From: Anita Gardner
Sent: 01 November 2019 13:09
To: Ross Funnell [REDACTED]
Subject: RE: LY/11/19/PL - Mrs D Johnson

From: planninghighways [REDACTED]
Sent: 24 October 2019 16:06
To: Planning.Responses <Planning.Responses@arun.gov.uk>
Subject: Response To Application Number LY/11/19/PL at Broomhurst Lodge Lyminster Road Littlehampton BN17 7QQ

TO:	Arun District Council FAO: Anita Gardner
FROM:	WSCC - Highways Authority
DATE:	24 October 2019
LOCATION:	Broomhurst Lodge Lyminster Road Littlehampton BN17 7QQ
SUBJECT:	LY/11/19/PL New access construction to serve as an access for Broomhurst Farm & its residents.
DATE OF SITE VISIT:	n/a
RECOMMENDATION:	More Information
S106 CONTRIBUTION TOTAL:	n/a

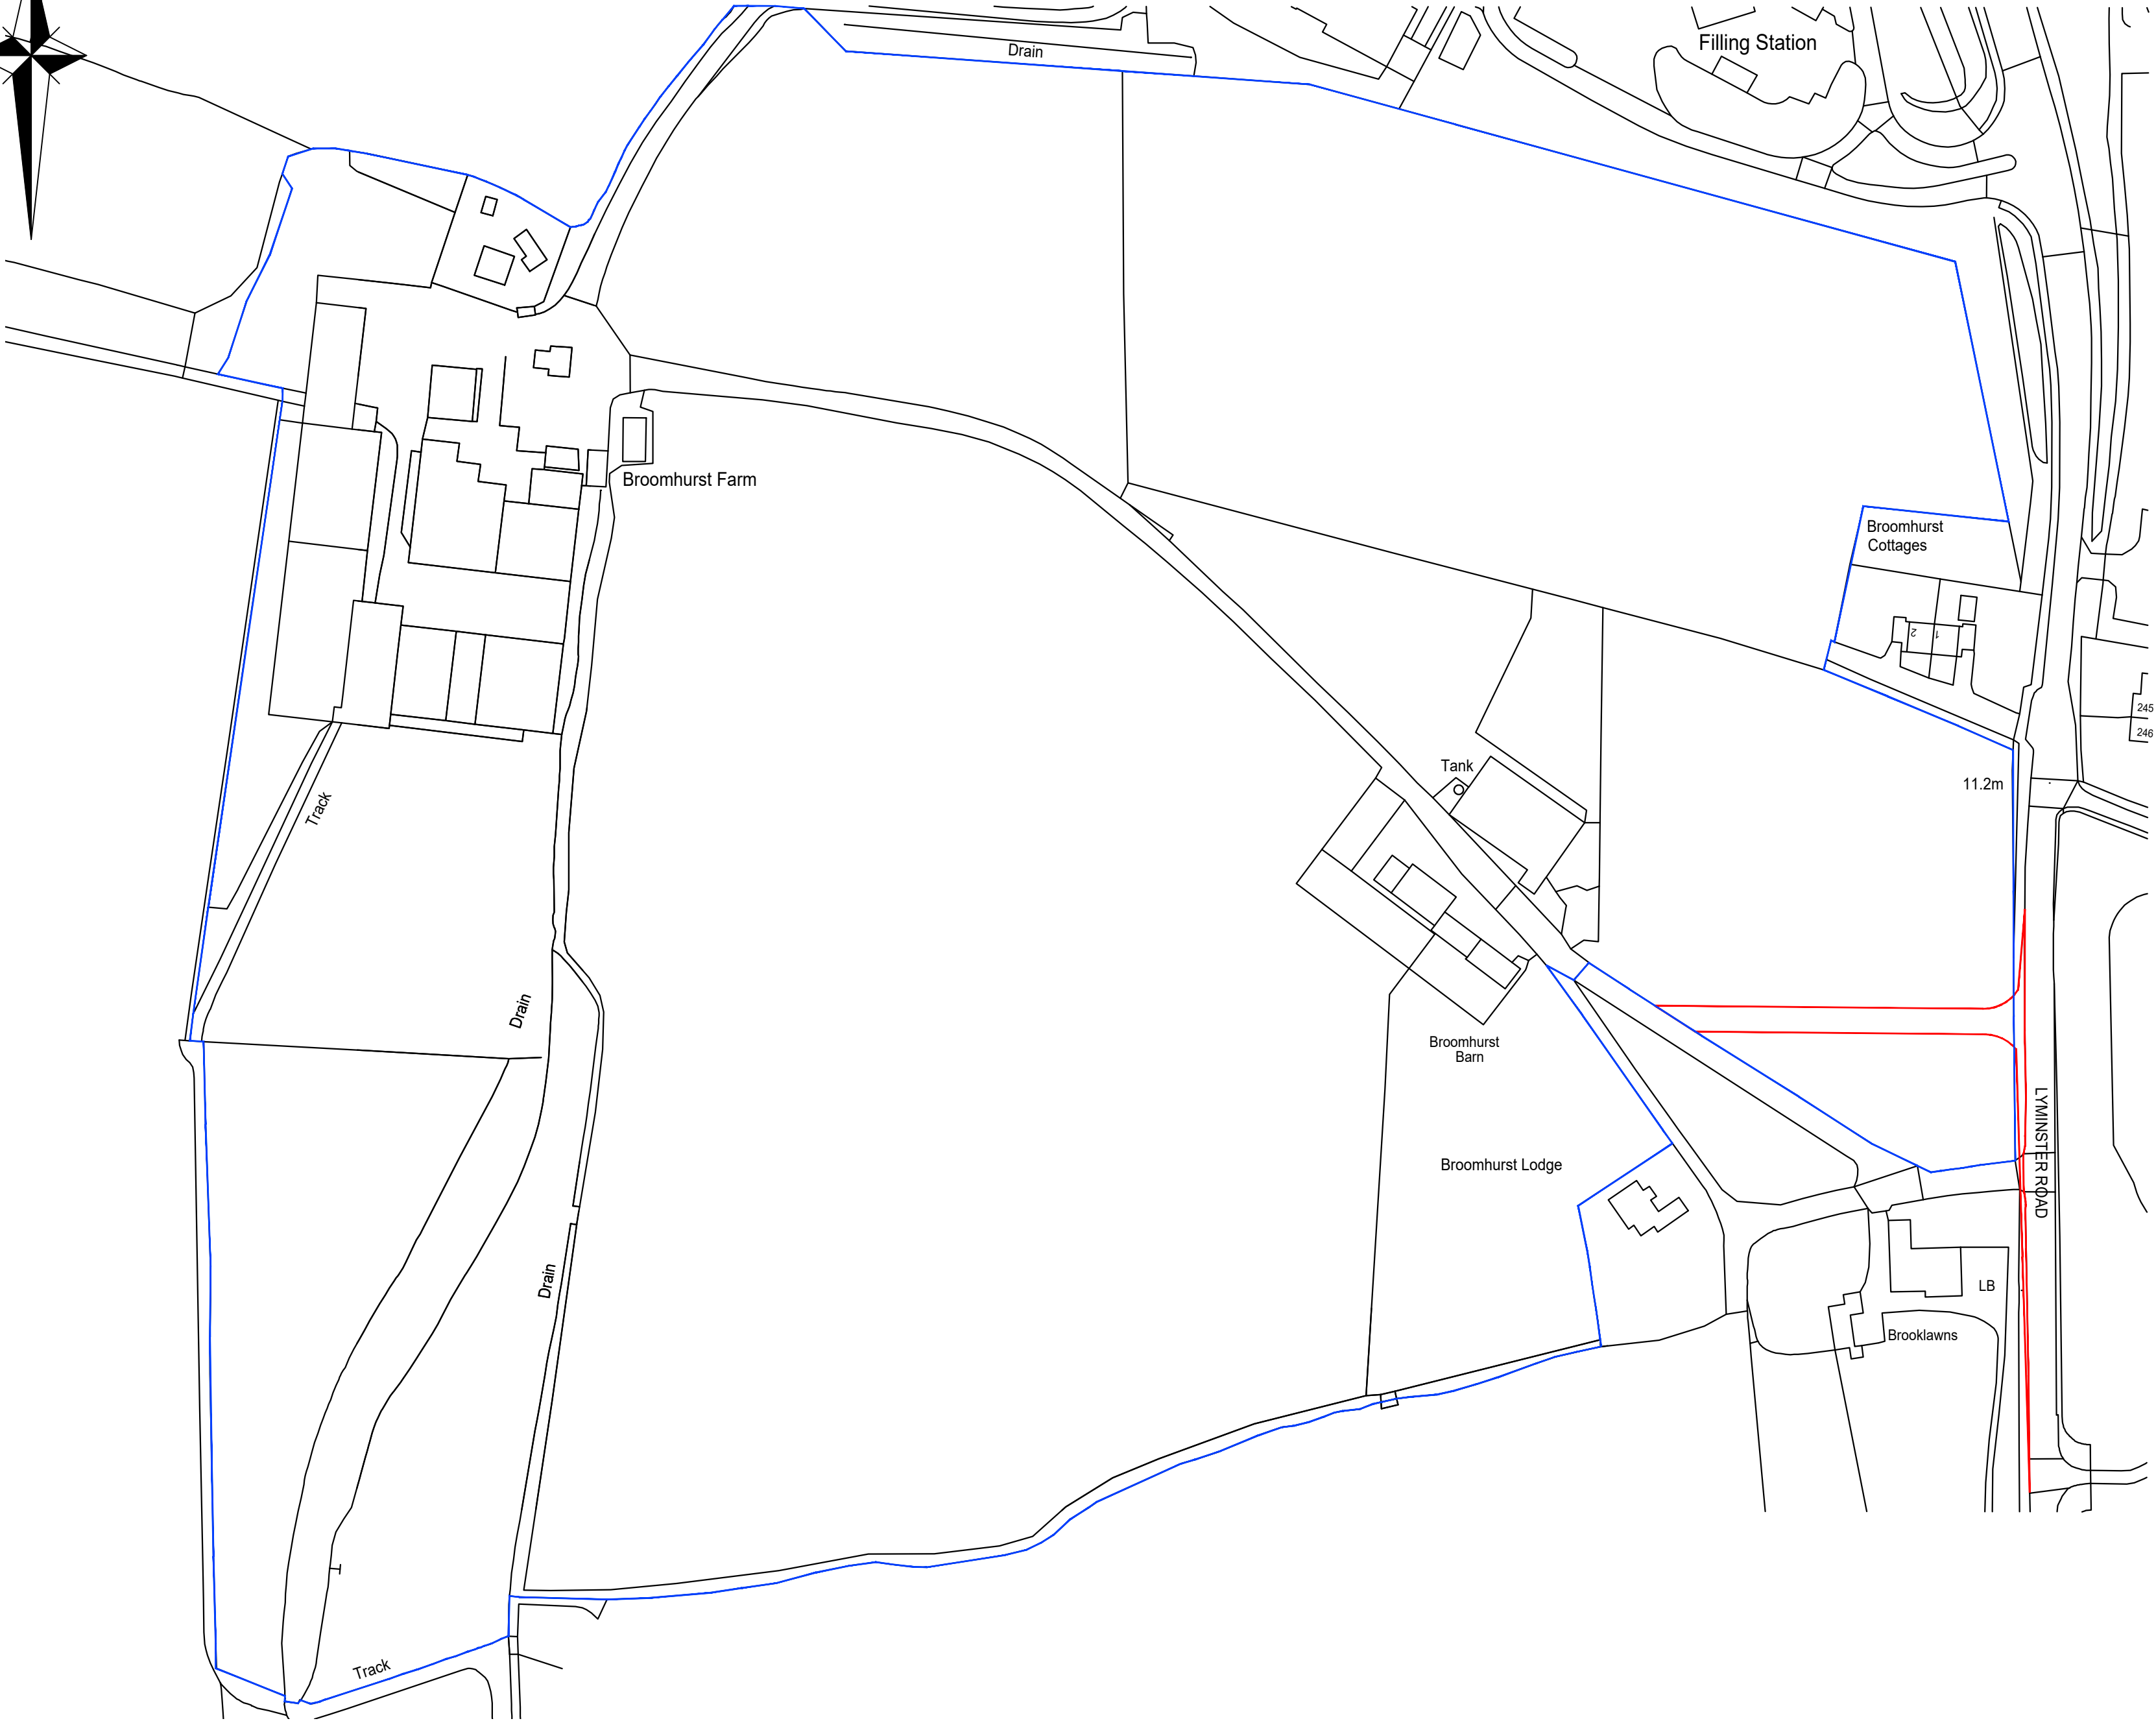
The applicant has provided plans demonstrating the minimum requirement for visibility as per Design Manual for Roads and bridges (DMRB) of 2.4 x 120 metres. The LHA however recognise that visibility in this area is greater than that proposed.

The applicant has demonstrated swept path tracking in accordance with WSCC guidance. This shows that farm traffic would have the ability to enter and exit the proposed access without detrimentally affecting highways safety.
